Date: March 8, 2021

From: Jeremy Johnston, Planning Official
(509) 962-7065, jeremy.johnston@co.kittitas.wa.us

Subject: CDS Review of LPF-21-00001 Pass Life Origins Final Plat – Request for additional information

**THE PASS LIFE AT THE VILLAGE AT THE SUMMIT, DIVISION 3, PHASE 3**  
 A PLANNED UNIT DEVELOPMENT  
 A PORTION OF THE SOUTH 1/2 OF SECTION 4,  
 TOWNSHIP 22 NORTH, RANGE 11 EAST, W.M., KITTITAS COUNTY, WASHINGTON

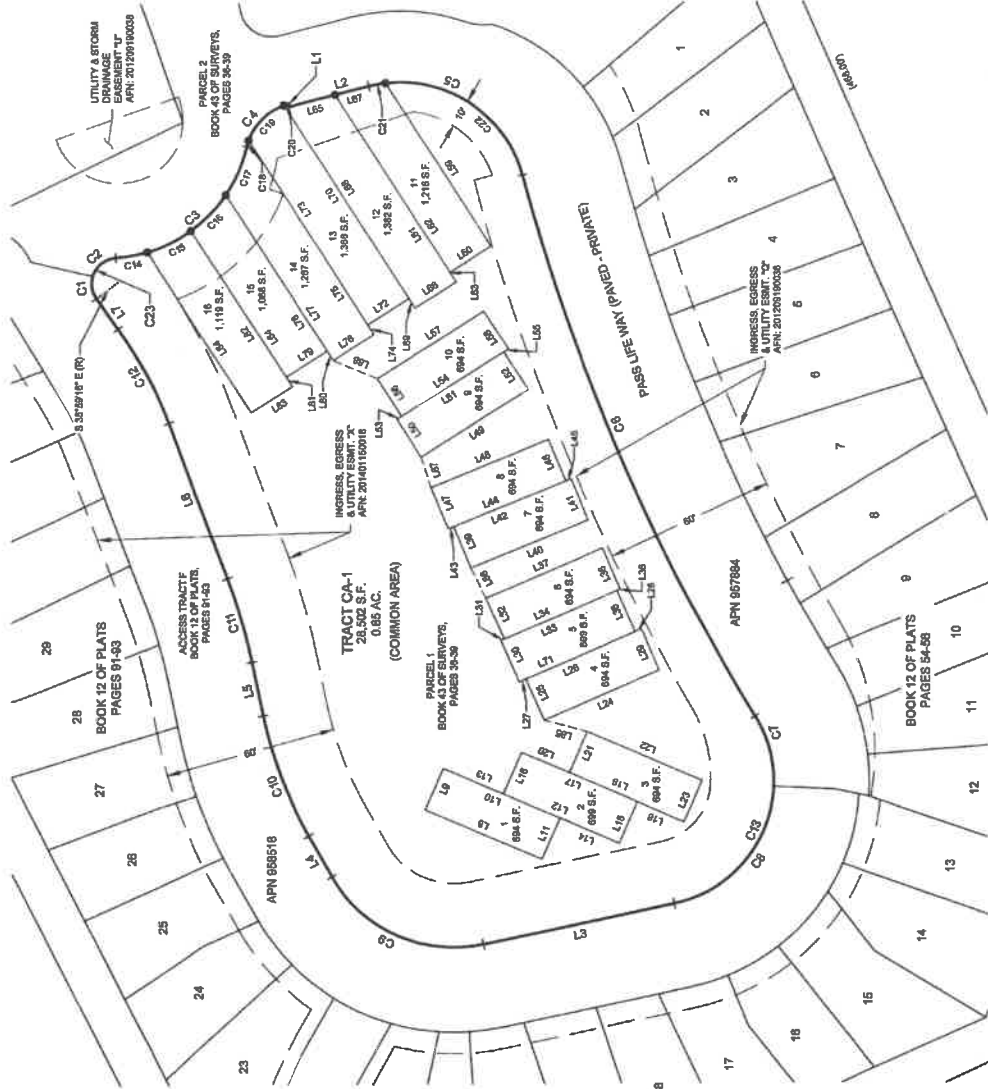
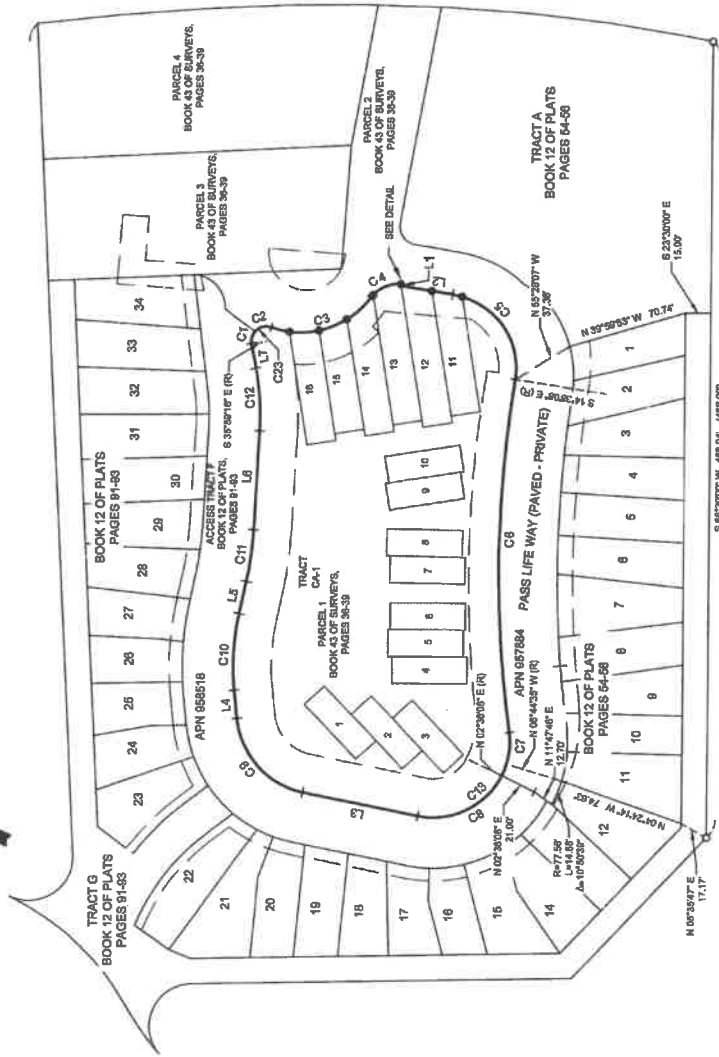
- The final mylars shall note the final plat file number LPF-21-00001 on the face of the plat.
- Taxes on parcel #957885 must be paid in full before final signature.
